From: Kate Giddings >
Sent: 18 February 2020 17:08
To: Amy Myer
Cc: Planning.Responses
Subject: Be/17/20/DOC - Site 6, Chichester Road, North Bersted

It is my understanding of the ADC Parking Standards Supplementary Planning Document that 100% of houses with garages or driveways shall have an electric vehicle charging point and that a certain percentage of other parking spaces should have active charge points. From the Site Layout Phase 4C document, it appears that there are five electric supply points to garages but it is not clear if this is solely the supply point or the actual charging point.

DRG No. S814/Ph4c/01	REV. G
-------------------------	-----------

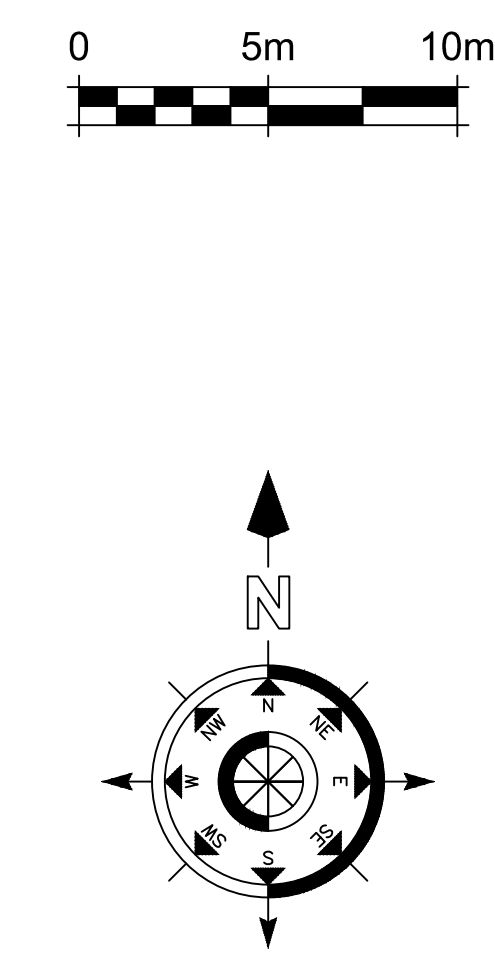
It is anticipated that every property with a garage or driveway will have their own electric vehicle charging point unless there is a justifiable reason as to why it is not possible. Furthermore, residents of flats and/or apartments should have access to a shared charging point, as per the percentage stated in the Parking Standards document.
